SUBJECT: D-49 Elementary School
Response to Comments Memorandum - TIS
LSC #174040

Following are the LSC Transportation consultants, Inc. responses to the May 15, 2017 El Paso County Planning and Community Development Department comments regarding the May 3, 2017 Traffic Impact Study by LSC. The updated traffic impact study is attached.

D49 Elementary School Traffic Impact Analysis (LSC #174040) May 30, 2017

GENERAL NOTES (CONTINUED)  
Londonderry Dr. and Towner Ave.  
Signing and Striping Modifications Plan

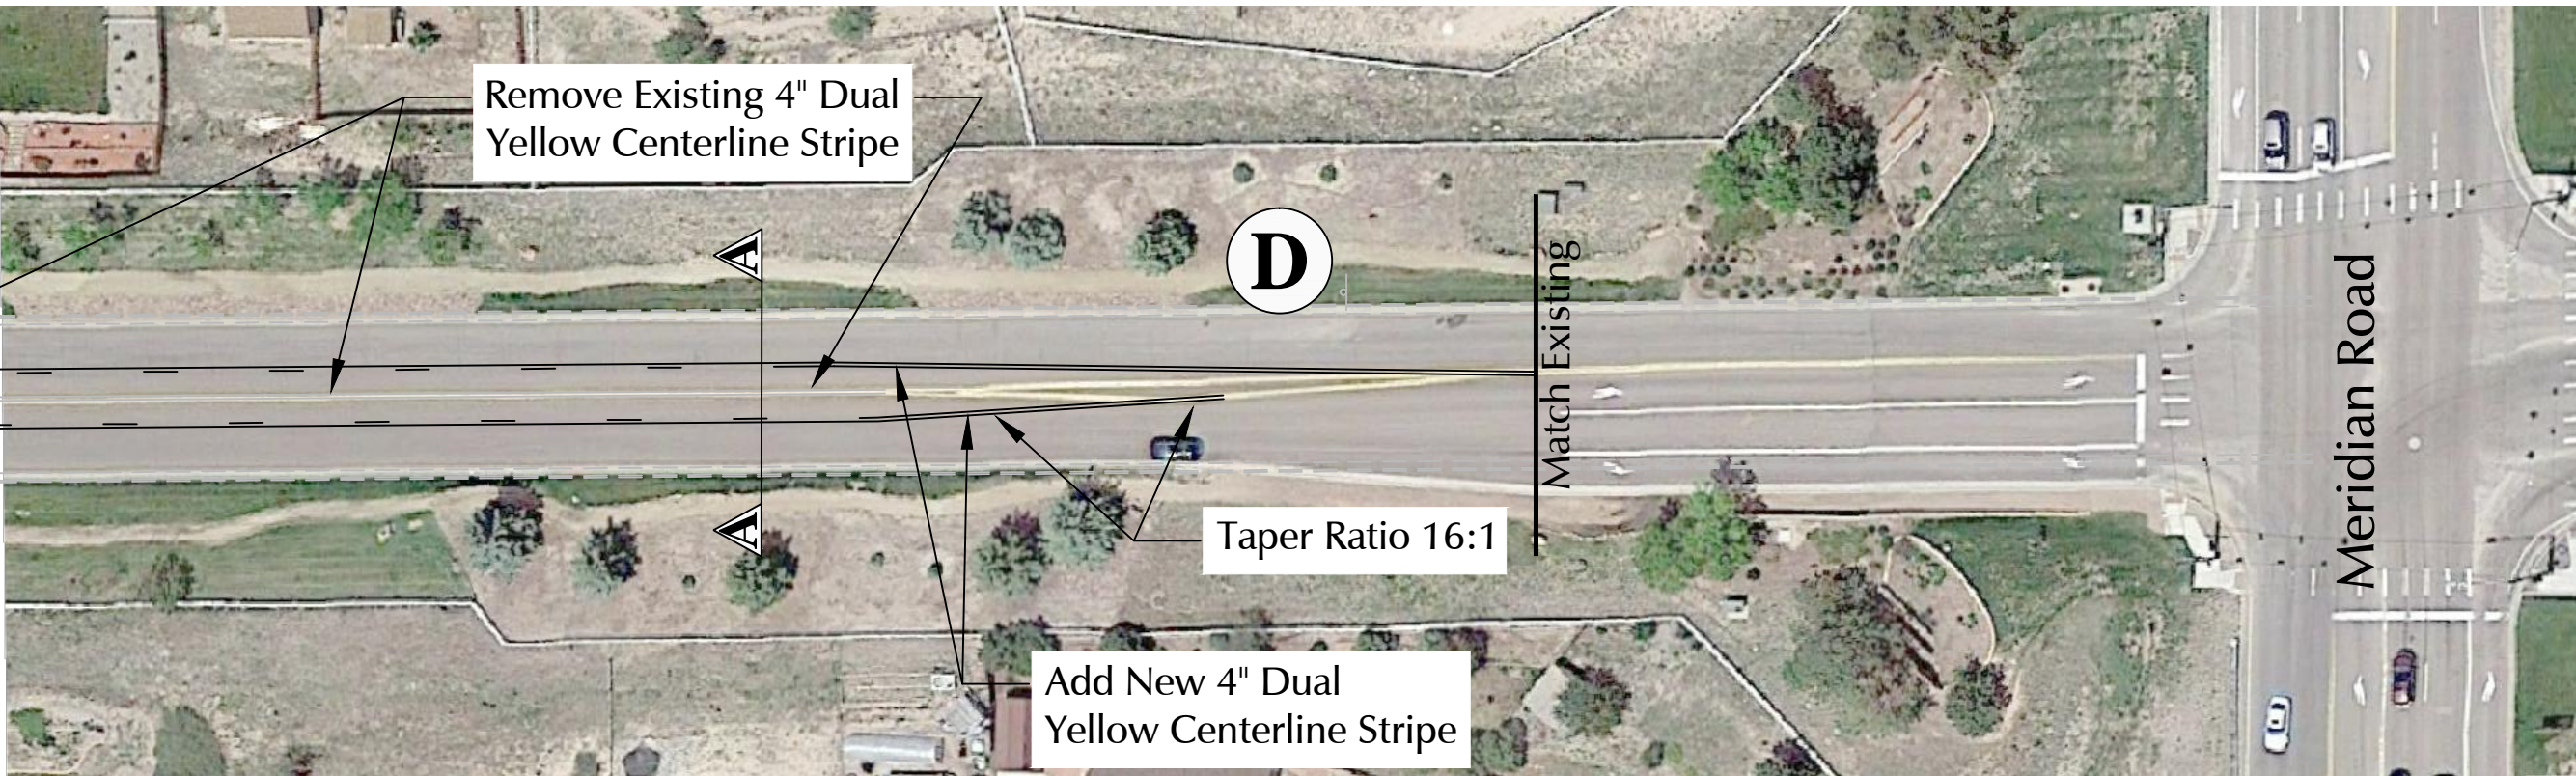
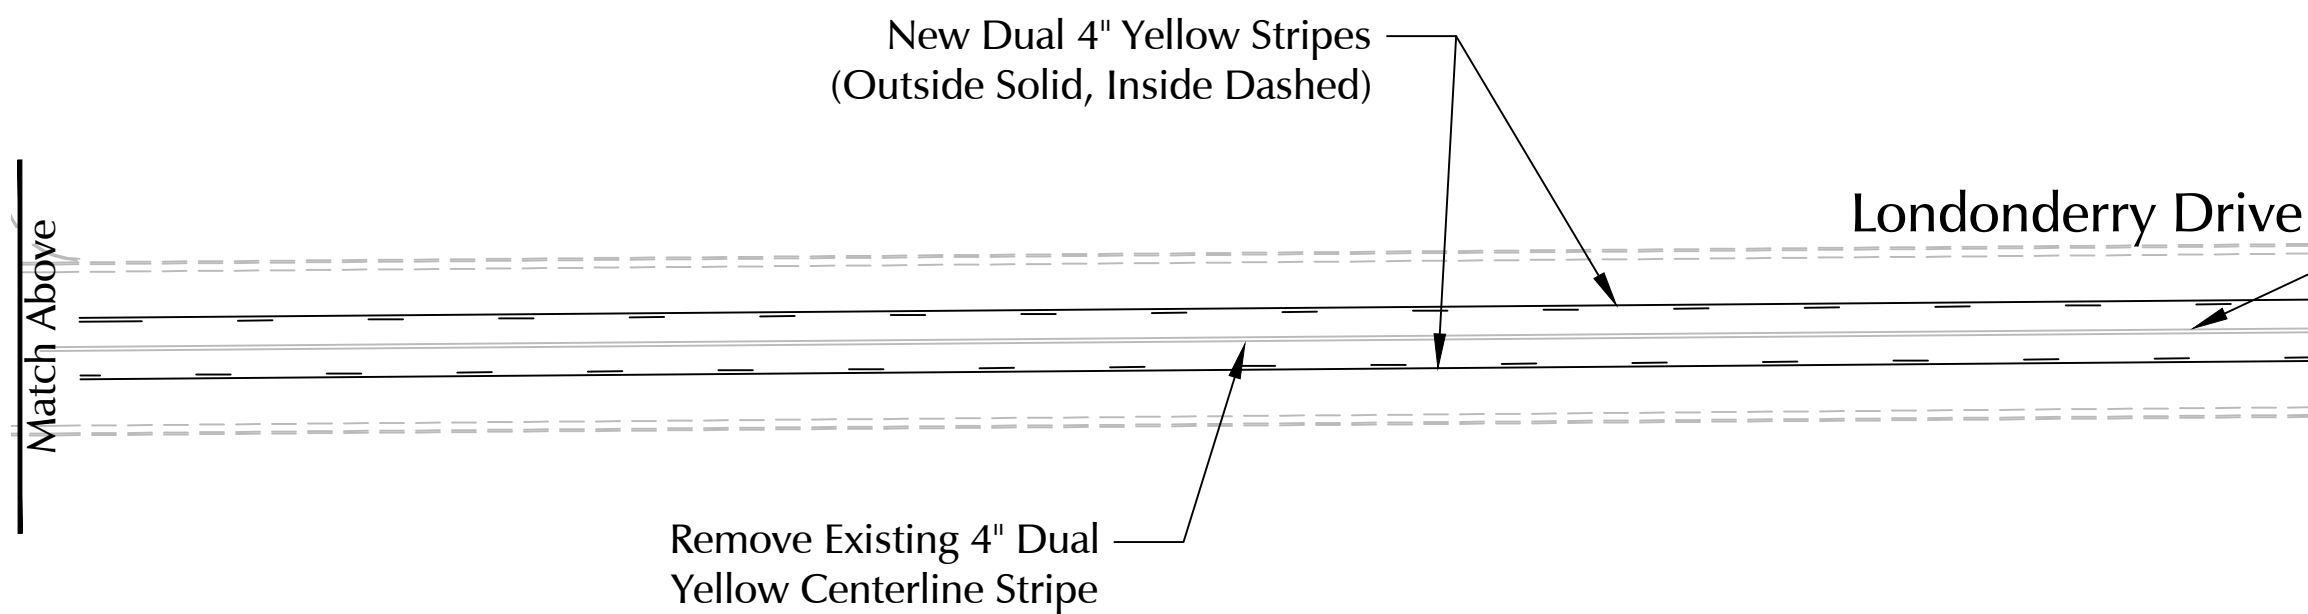
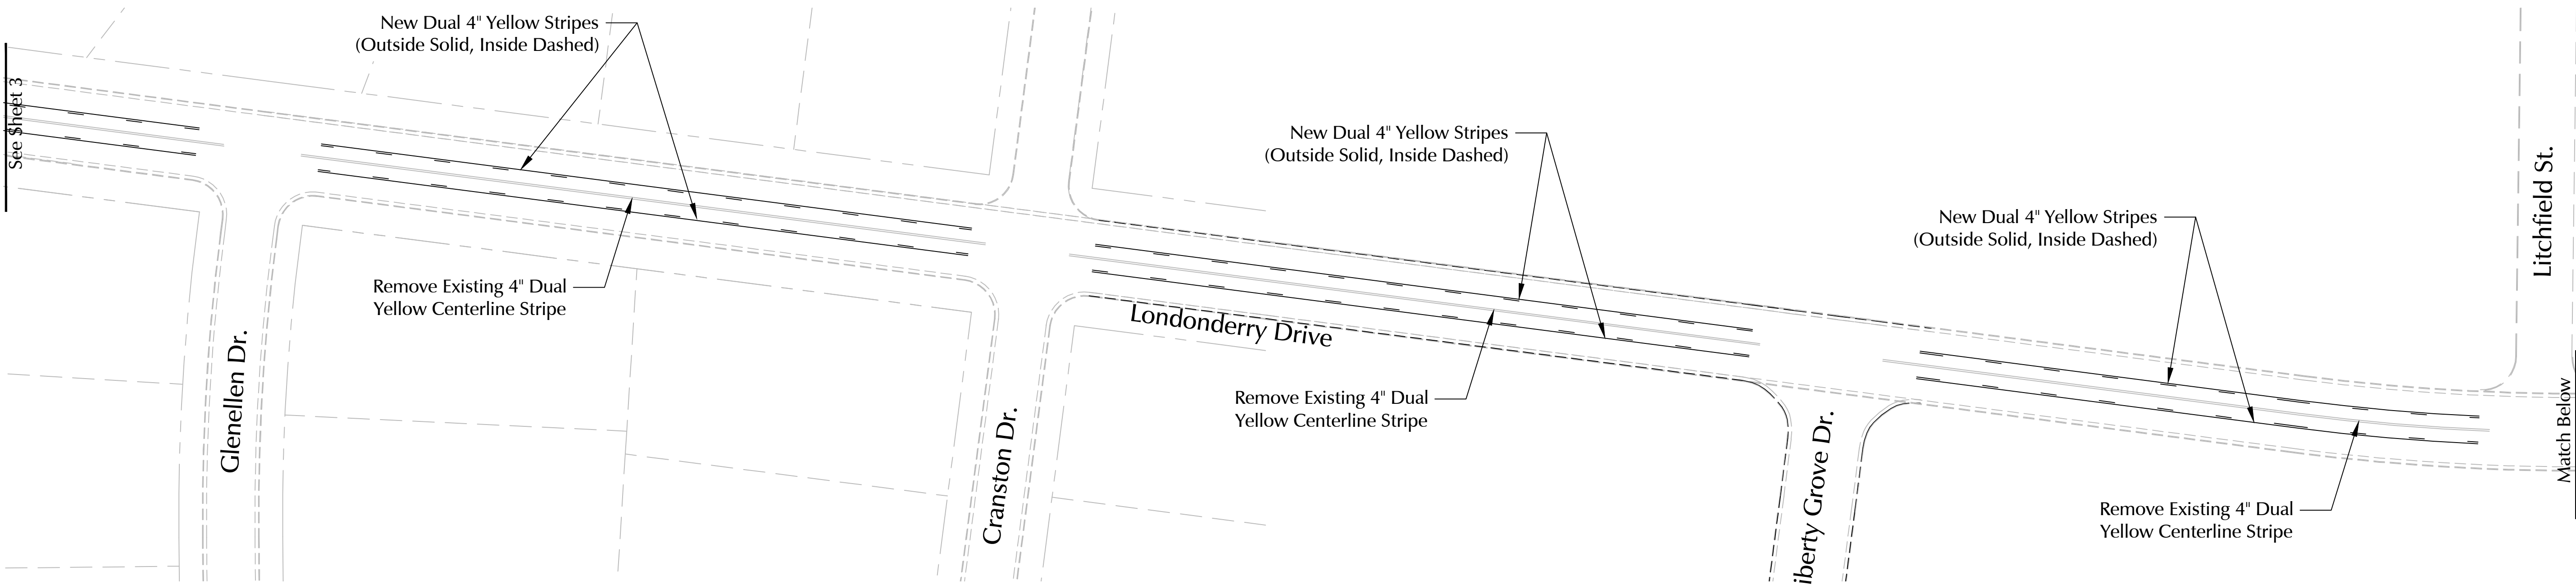
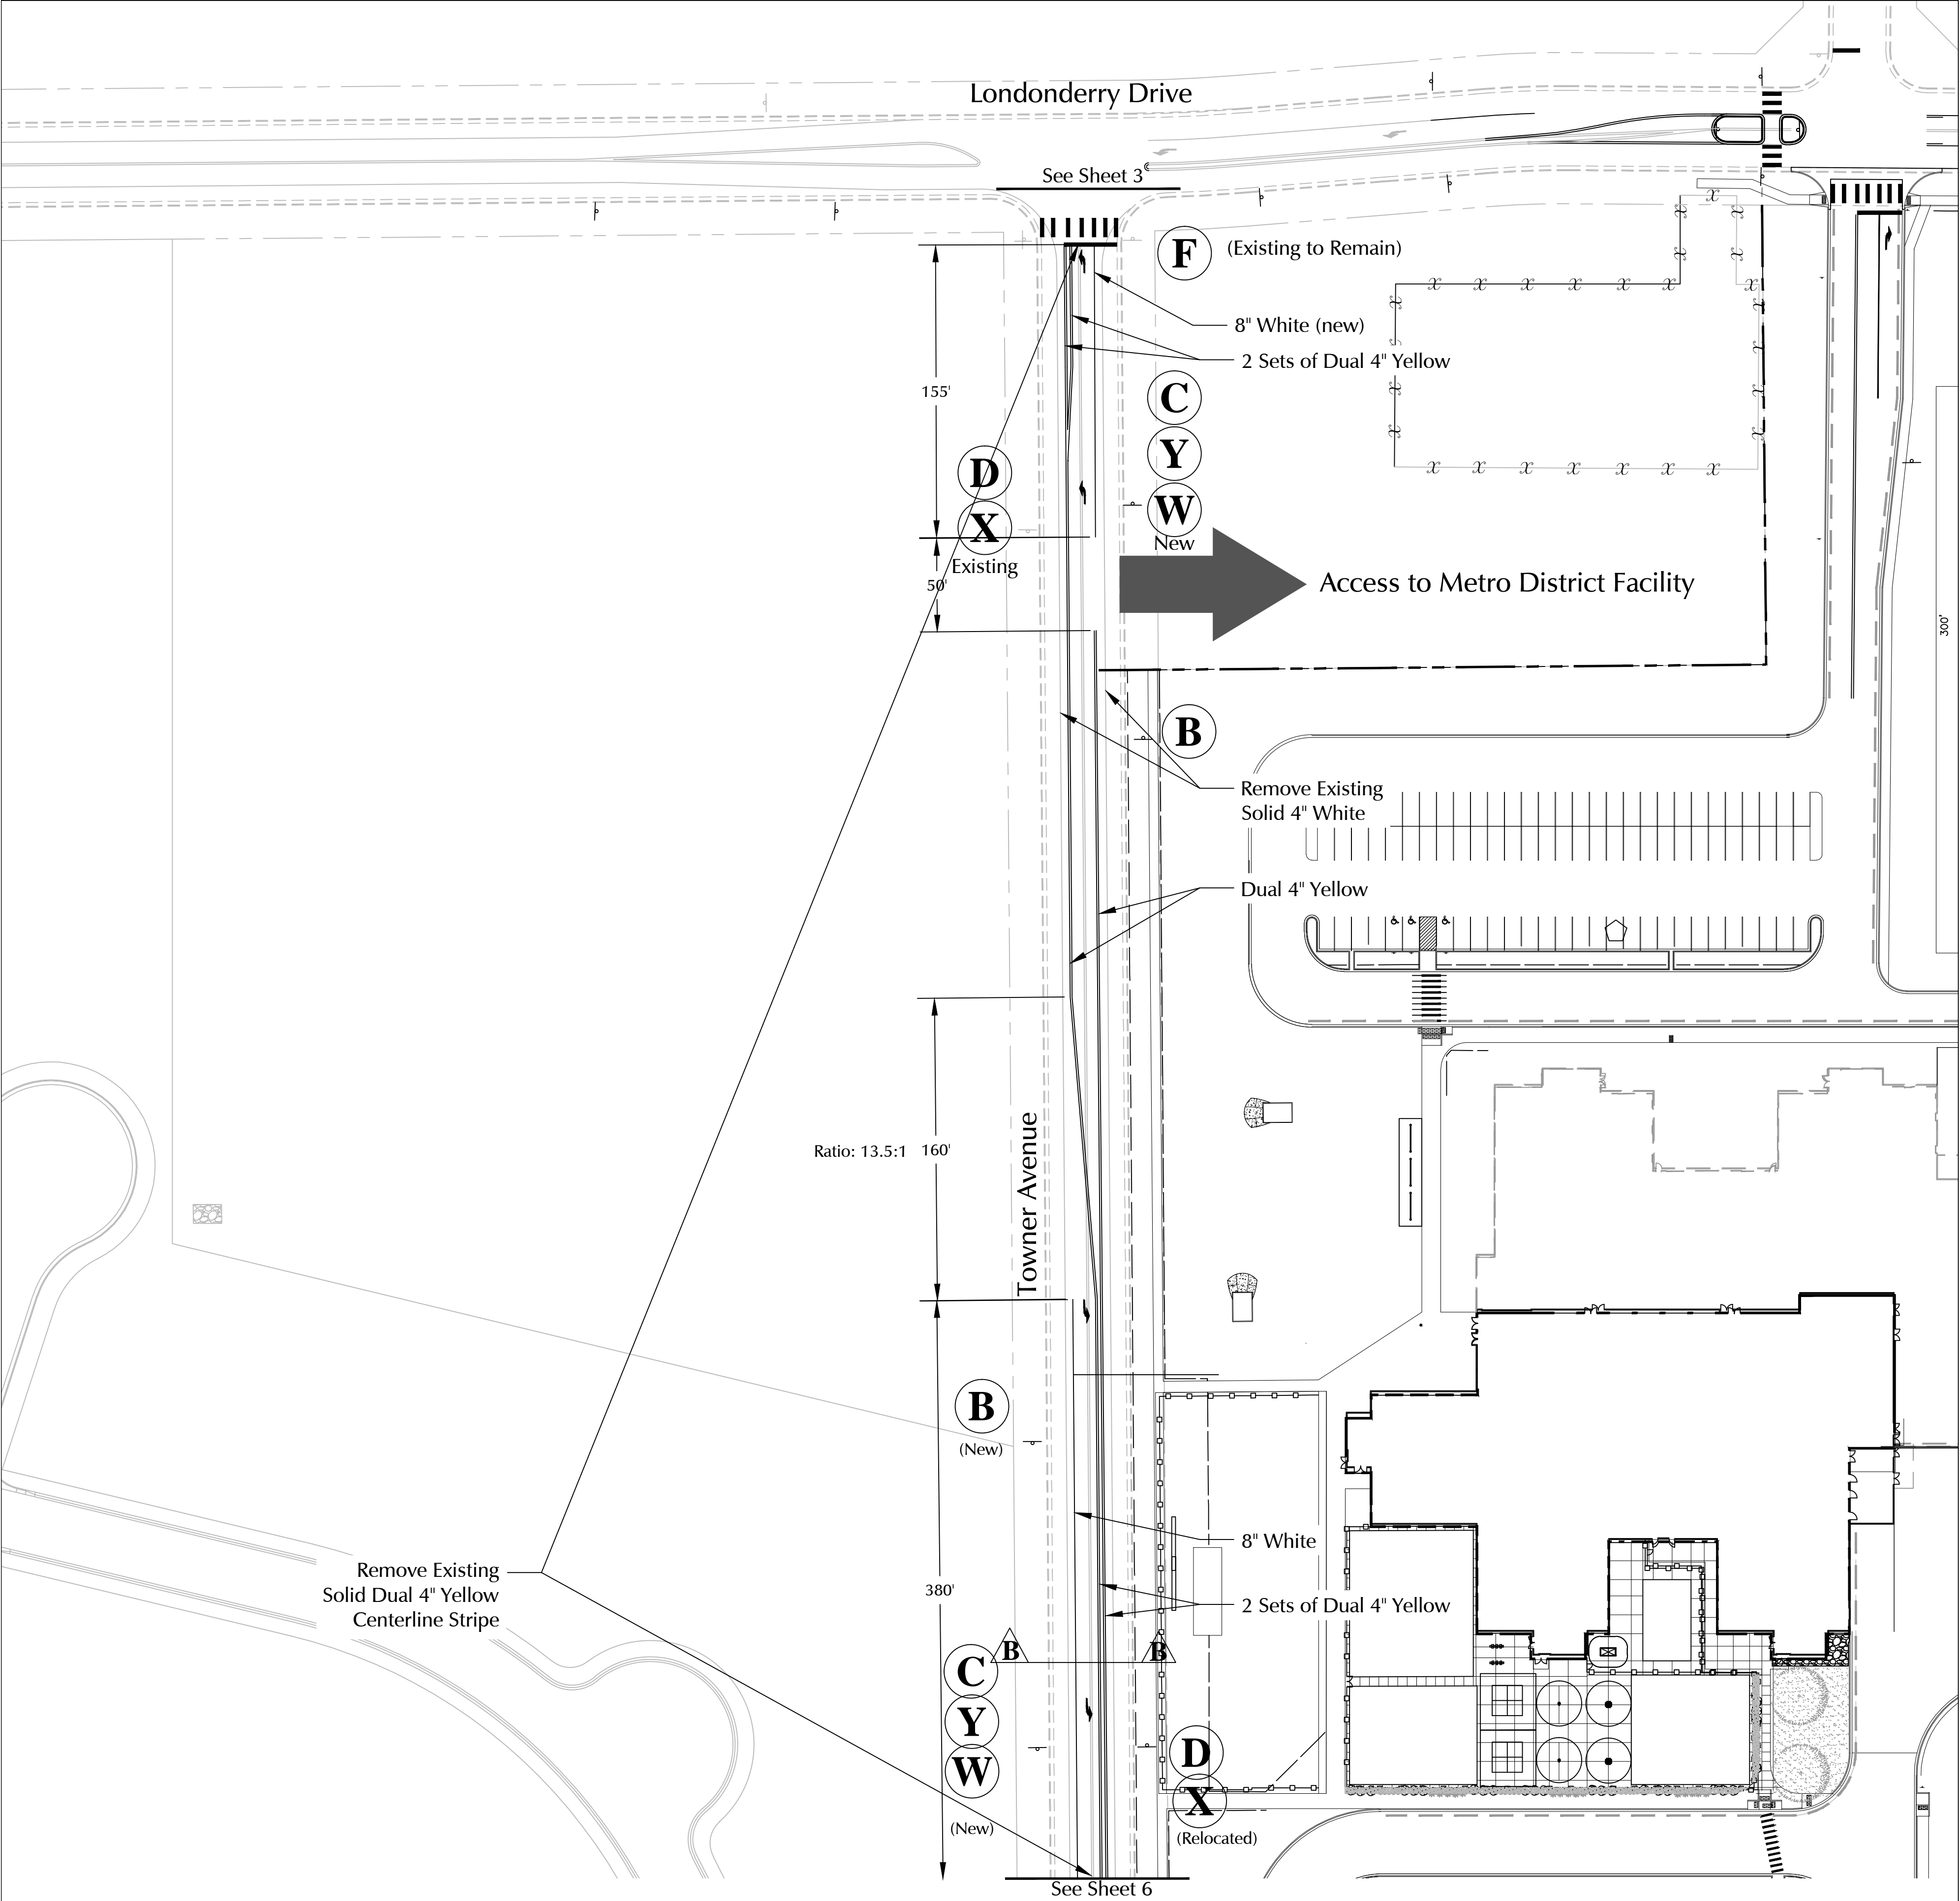
Are you anticipating a separate plan set or will it be included on the next resubmittal? [re: A Towner striping/signing plan]

LSC Response: A separate plan set will be included on the next resubmittal. A note has also been placed on the Londonderry plan sheet.
